Response to WSCC Strategic Planning Consultation Comments dated 6 September 2012

Proposed housing development at

**Roundstone Lane, Angmering
Arun Planning Application A/82/12**

23 November 2012

2011 Observed Queue Lengths
AM Peak Hour

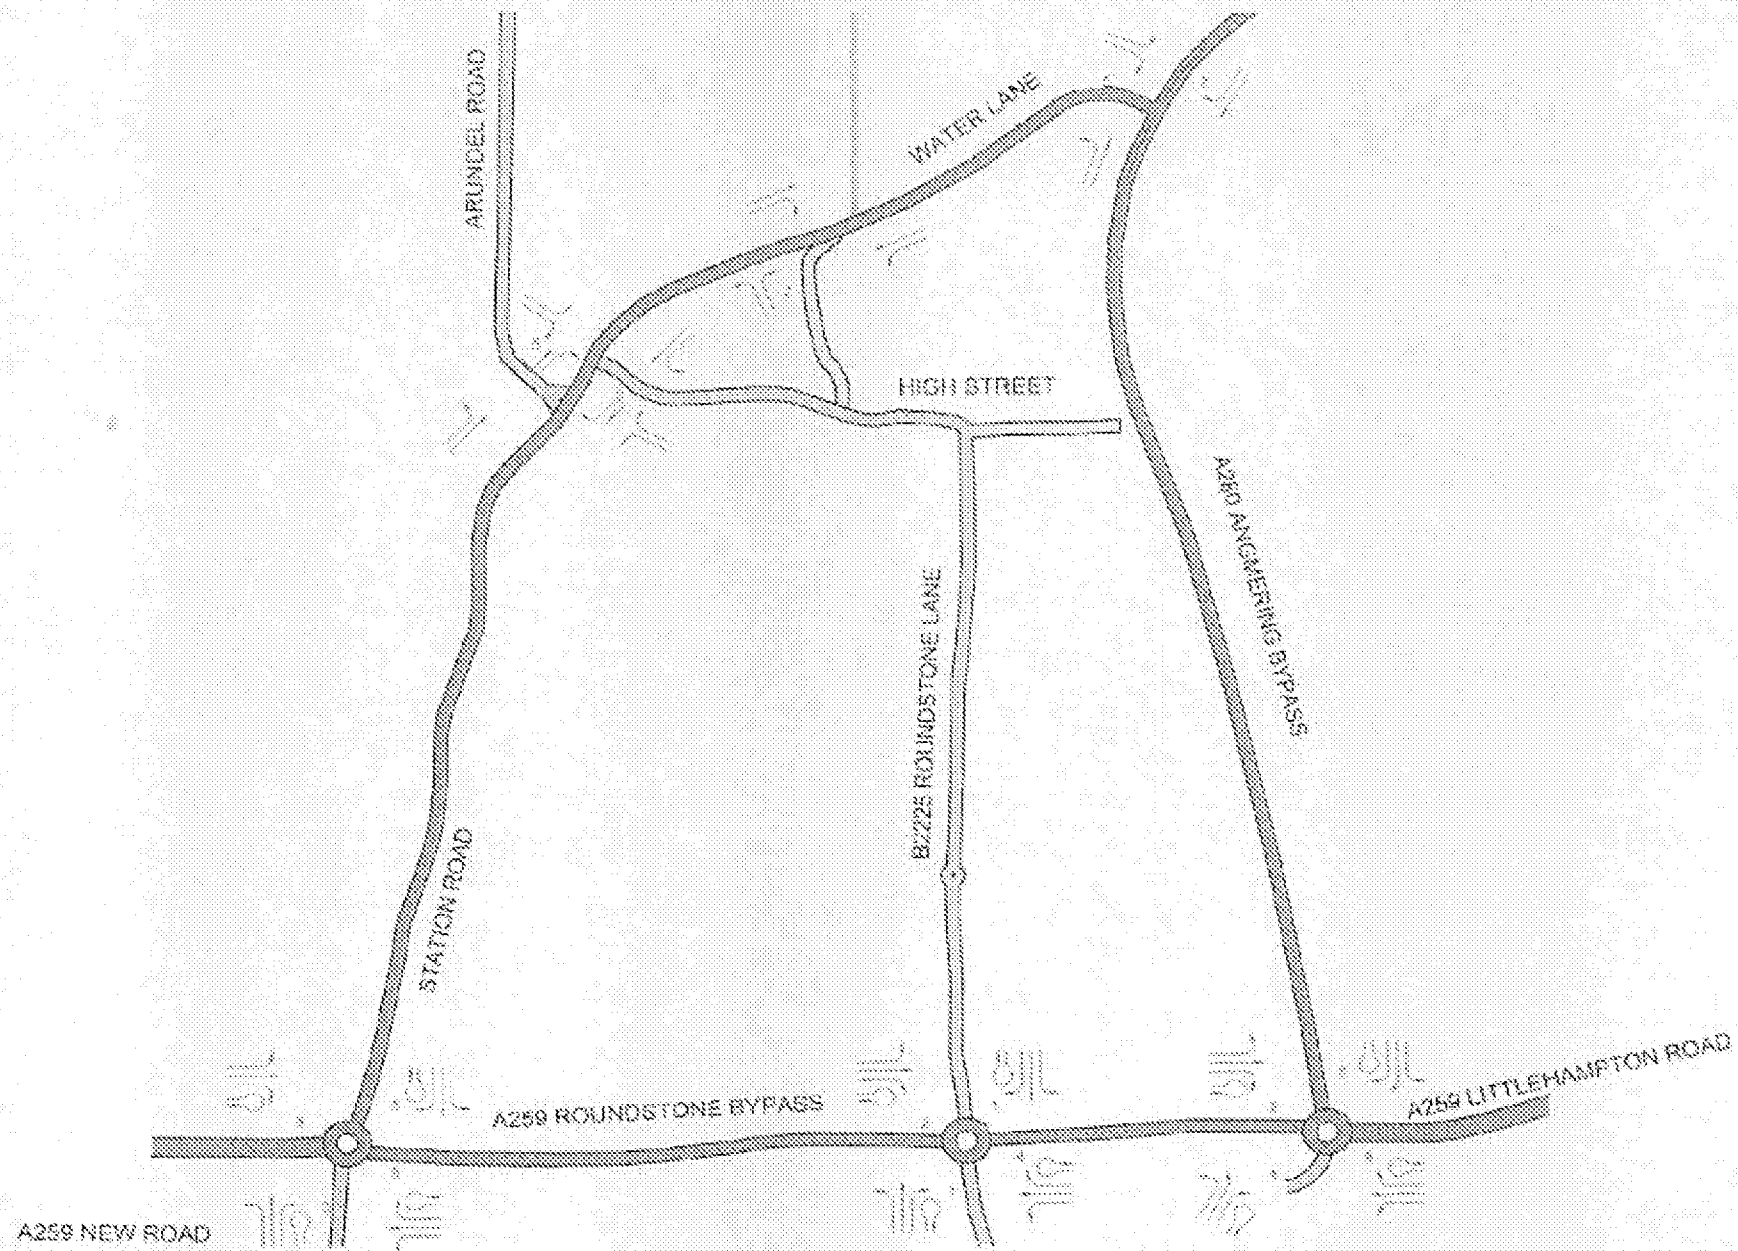
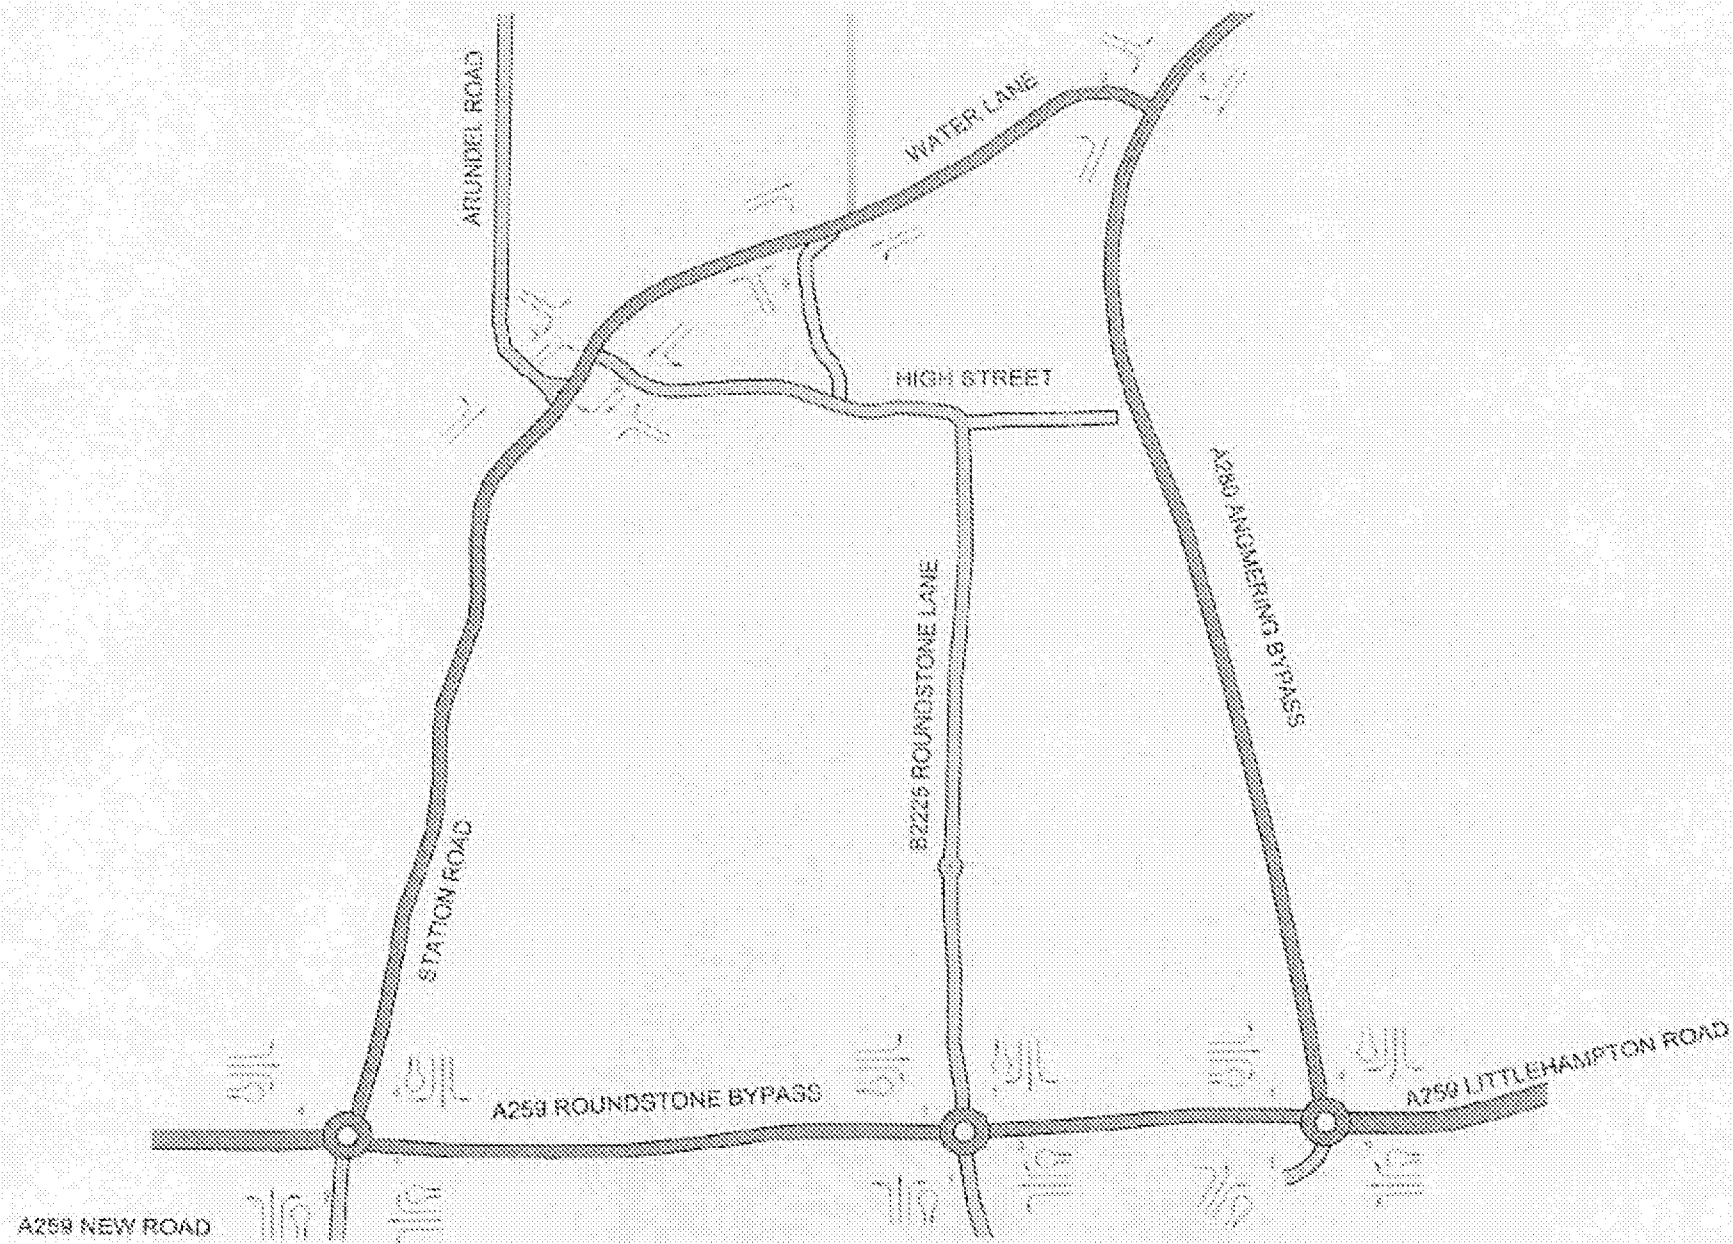
'Junction assessments: These do not appear to be consistent with observed traffic conditions on the A259 or at Water Lane/A283. The queue lengths in Appendix 11 appear to be lower than actual observed queue lengths during the morning and evening peak hours. Further detail should be provided on the junction assessments relating to the A259 to explain the relationship between observed congestion and the technical junction assessments.'

Queue length data taken during the traffic survey together with a summary in table and also schematic format is attached in Appendix 1 at the rear of this note.

The observed lengths in vehicles were noted every five minutes by the survey company. The summary queue lengths compiled by us from this data are mean average PCUs to match the definition of queue in TRL's ARCADY method. Capacity models are based on geometrical measurements taken from Ordnance Survey and aerial photograph. Percentage arm capacity adjustments have been undertaken where necessary such that the output from the ARCADY base model shows similar results.

We believe this industry standard approach provides adequately representative models however there are two reasons the traffic conditions observed might differ from the modelling results which are worth noting before attempting to produce more 'accurate' models:

1 – Natural variance and definition of queue. The queues reported from ARCADY are mean average static queues over time segments. This does not include slow moving traffic approaching a junction or demonstrate the maximum observable number of stopped vehicles at any particular time or any particular day. It can be seen from the raw queue length data that as expected at peak times there is a significant variance in queue length. There would also be significant daily variance not able to be incorporated into the models.

2 – Congestion from downstream delays beyond the roundabouts may have been observed which is not a capacity failing of the roundabout itself and would not be appropriate to artificially throttle the performance of the roundabout to mimic this since alteration to that roundabout would not solve the problem.

Nevertheless we believe the models represent the geometry and delay on the ground and produce a fair assessment of the likely increases in queue and delays due to development which are of course small in proportion to the small increase in traffic flow due to development.
